My Ref: 2016/ENQ/00558
Your Ref:
Date: 6th September 2022
Enquiries to: Hannah Andrew
Direct Dial: 01226 775752
E-Mail: hannahandrew@barnsley.gov.uk

Discharge of conditions 3, 5, 7, 8, 9, 11, 14 and 18 of app 2015/1198 - Erection of 61 dwellings with garages and/or parking spaces together with the provision of open space and associated roads and sewers.

Barnburgh Lane, Goldthorpe, Barnsley

project Non-Standard Details
 client Gleeson Homes & Regeneration
 title Tarmac Drive and Shared Drive Details (Concrete Edgings)

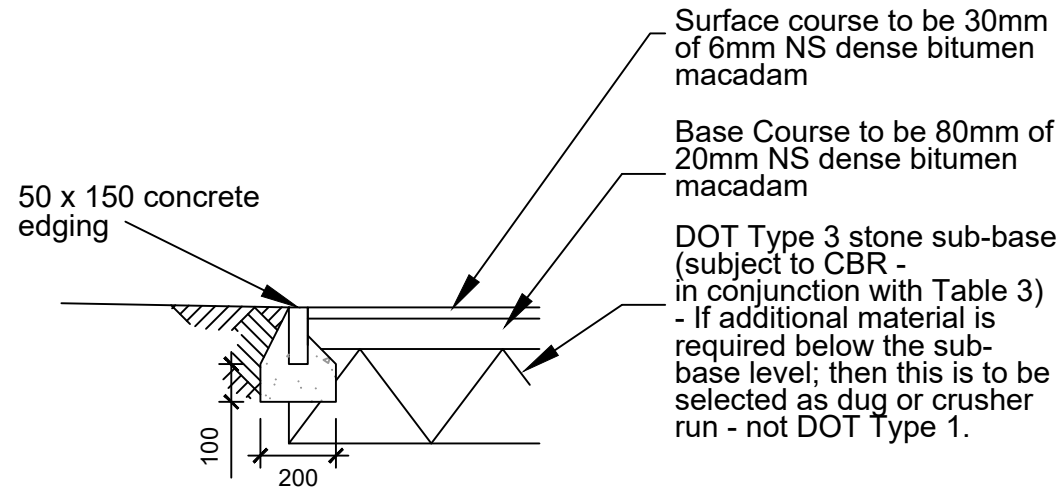
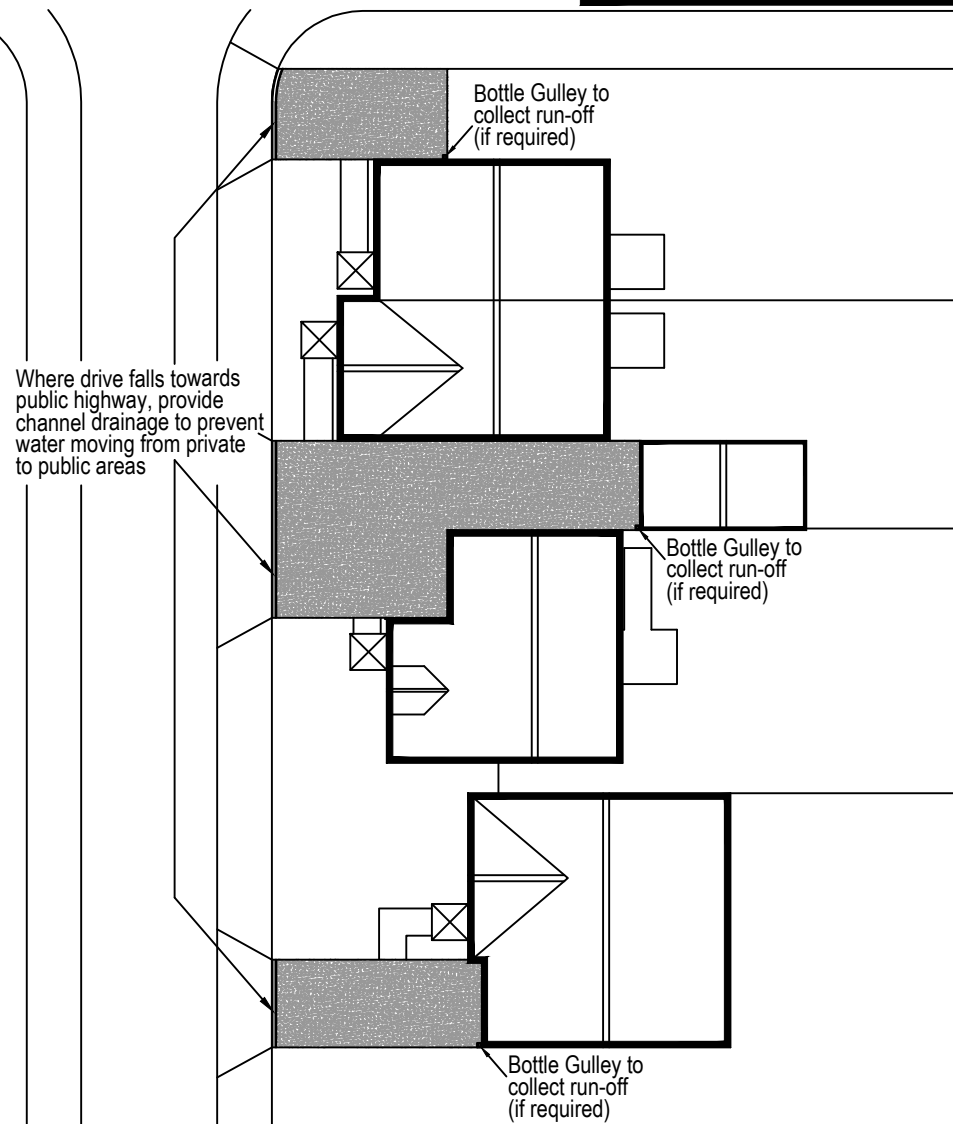
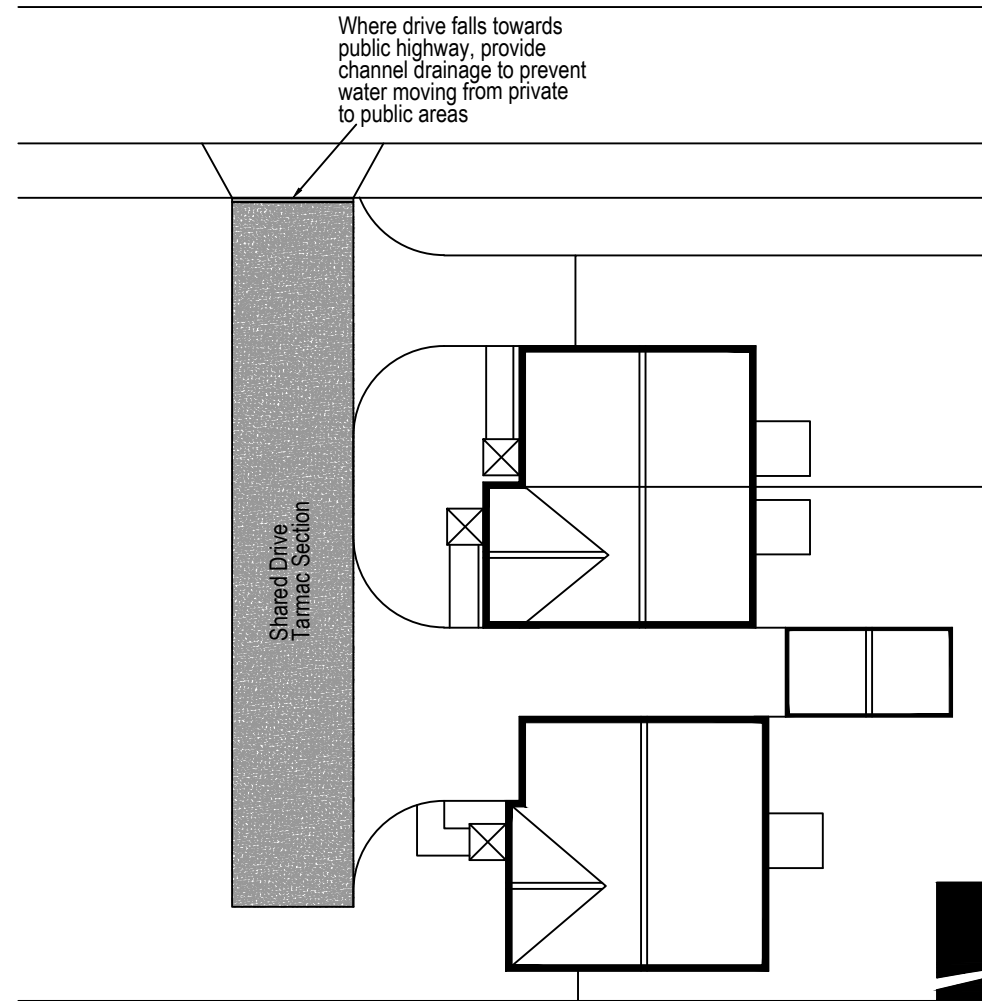
Condition 4 – The issues around this condition have been resolved through the appeal process and the Tarmac Drive and Shared Drive Details (Concrete Edgings) NSD711 Rev A is acceptable.
